Application number: 2022/92406	
What is the application for?:	Erection of 10 affordable dwellings, with access from Chapelgate and associated
Address of the site or building:	Land Adj, 67, Chapelgate, Scholes, Holmfirth, HD9 1SX
Postcode:	HD9 3BW

Type of comment: An objection	
Do you wish your comments to be published on the website anonymously?	Yes
Due to the limitations of the submission form, I have divided my comments into 2 parts. Part 2 of a 2 part objection. Impact on the immediate surroundings. The applicant makes a statement which begins "The proposed development has due regard to its setting on the fringe of the settlement in Scholes..." I dispute this statement. This land is greenbelt. It sits outside of the curtilage of the existing village. This development would dominate its surroundings, and create a new urban environment, with all the noise and light pollution that goes with it. The visual impact would be significant. The impact to wildlife would be significant, not just on the site itself but beyond. Additionally the use of large areas of render to the external faces of the buildings is very much out of keeping with the local aesthetic, which is almost exclusively

Boundary Treatment			
Name	(462)-GWP-01-01-D-A-(PA)-0005		
Scale	1:500@A3	Revision	P03
Drawn/Checked	CT / RT	First Issue	04.04.22
Drawing Status	S2 - Information

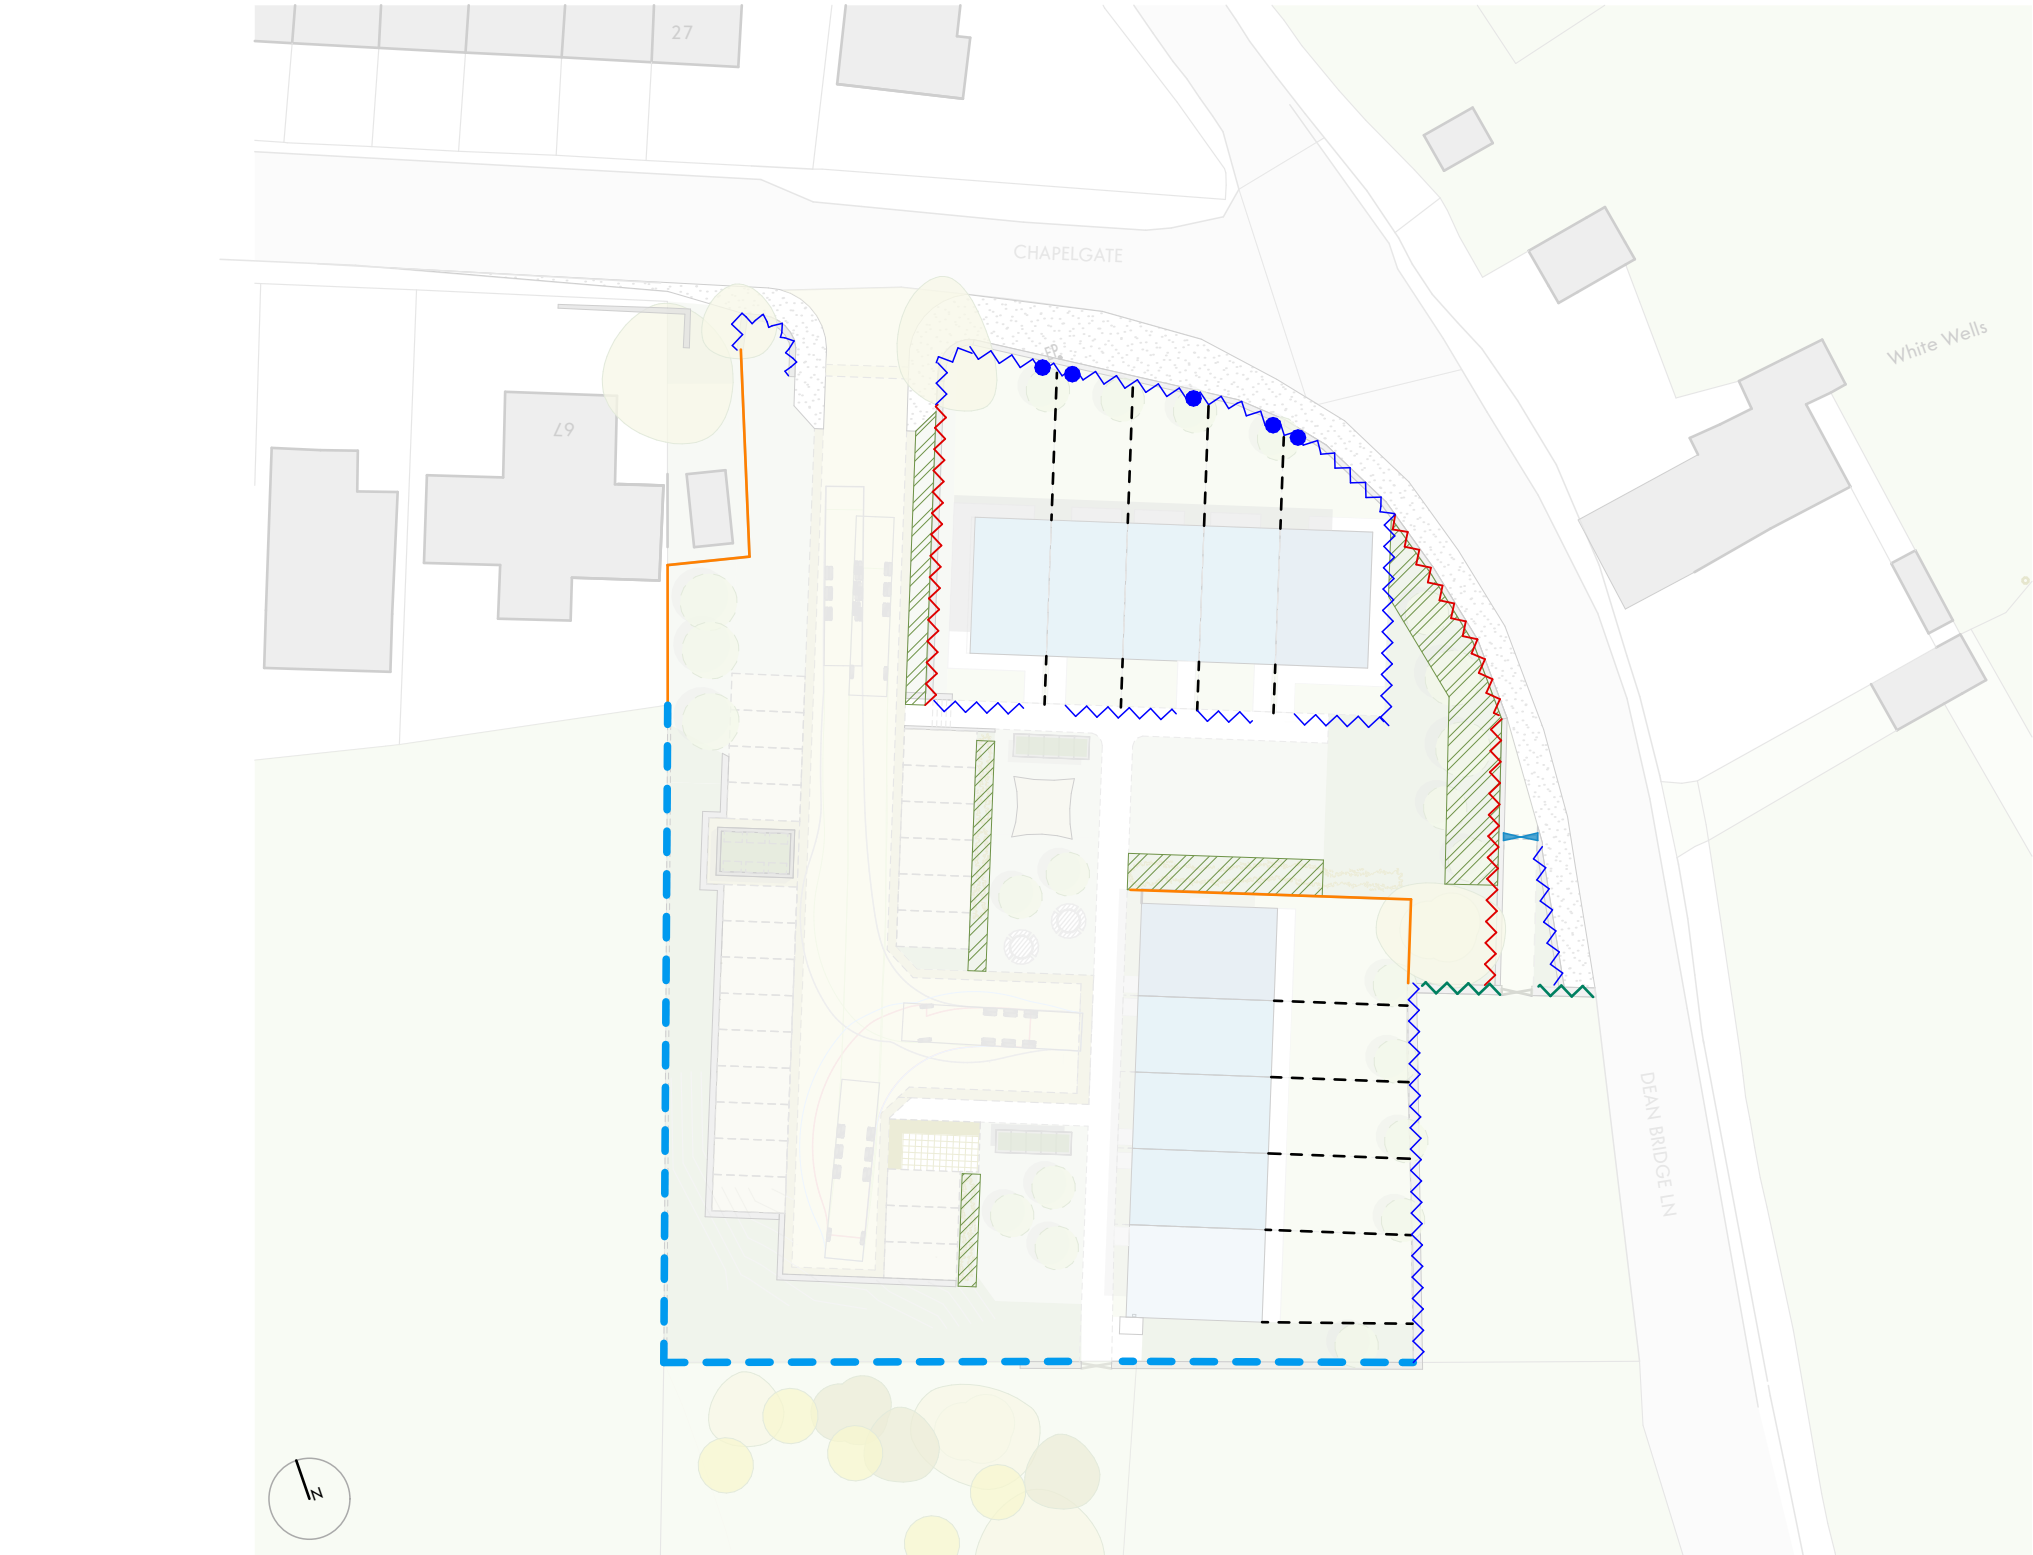
Use of Gabion Baskets.

The intention to use a gabion basket system behind the car parking spaces is both extremely ugly, and detrimental to wildlife habitat. Why anyone would want to hide the stone quarry face behind these things is beyond me.
